**Whytes Gully landfill extension (MP11\_0094)  
Response to exhibition of Environmental Impact Statement**

### Whytes Gully landfill extension (MP11\_0094)

#### Response to exhibition of EIS

#### Comment by NSW Office of Water

Figure 5: Recommended Buffer Distances along Riparian Corridors

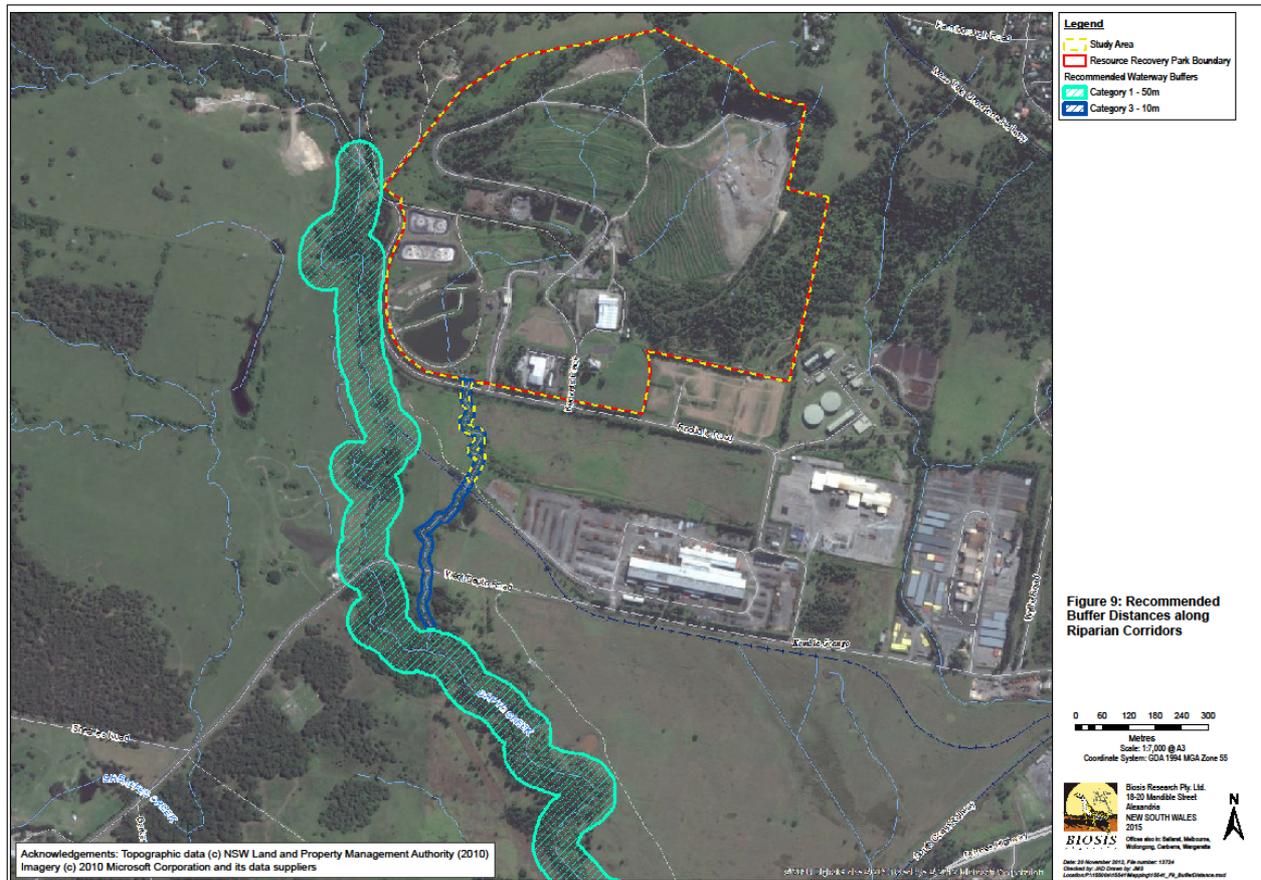
Section 3.5.4 of the Terrestrial and Aquatic Flora and Fauna Assessment (TAFFA) in Appendix F refers to the RCMS riparian buffer widths to be considered in the planning and design of the proposal. The EA (Section 13.3 ) and Section 4.2 of the TAFFA recommends as a mitigation measure to maintain suitable buffer distances from nearby waterways based on the stream orders of waterways and the subsequent categories identified within the Wollongong DCP (2009). It should be noted the riparian land management section in Wollongong DCP 2009 (Chapter E23) is not based on stream order but on the DIPNR (2004) Riparian Corridor Management Study. Map 7 in DIPNR (2004) is the relevant riparian map for the Whytes Gully site. It is not clear how the recommended buffer distances shown on Figure 9 in Appendix F have been derived.
